From: Vanessa Aziz <vaziz@cityofsydney.nsw.gov.au>
Sent: Thursday, 28 February 2019 2:43 PM
To: Lawren Drummond
Cc: Michael Soo
Subject: HPE CM: SSD 4972 MOD 7 Modification to Four Points By Sheraton Hotel Expansion

RE: SSD 4972 – Modification 7 seeks to use the current temporarily approved configuration permanently

Drawing Title
WHEAT ROAD
BUS BAY TURNING PATHS
1 OF 2

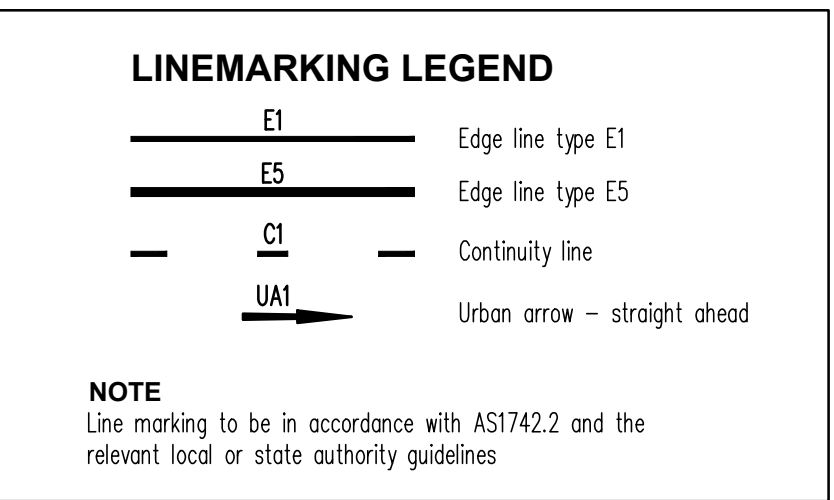
The approved final redesign of Wheat Road includes upgrading the pedestrian connection from the hotel to Cockle Bay/Darling Harbour via the extension of stairs over Wheat Road so that pedestrians would be free from negotiating traffic; an increase in the public domain on the Cockle Bay side of Wheat Road, meaning increased pedestrian entrance to Cockle Bay and increased area to tour groups etc. to gather; and the reconfiguration of the road to allow more buses to park at the rear of the Sydney Aquarium and Cockle Bay precinct.

It is noted that the footpath/pedestrian area levels on the Cockle Bay side of the road do not appear to be compliant with the City's grades for public areas. There is an opportunity, under the approved plans, for levels within this area of the public domain to be improved.

By not implementing the already approved Wheat Road reconfiguration and retaining the existing temporary public domain layout would be a missed opportunity to improve pedestrian connections and safety in the area which provides key access for tourists from a major hotel to Cockle Bay and Darling Harbour.

Upgrading the public domain and Wheat Road configuration to the approved design is a much more desirable outcome as it improves pedestrian/tourist connections by providing a direct and safe route to Darling Harbour from the hotel and Sussex Street. The increased public footpath space approved to the Cockle Bay side of the road will provide more space for groups to congregate, particularly when getting on and off coaches.
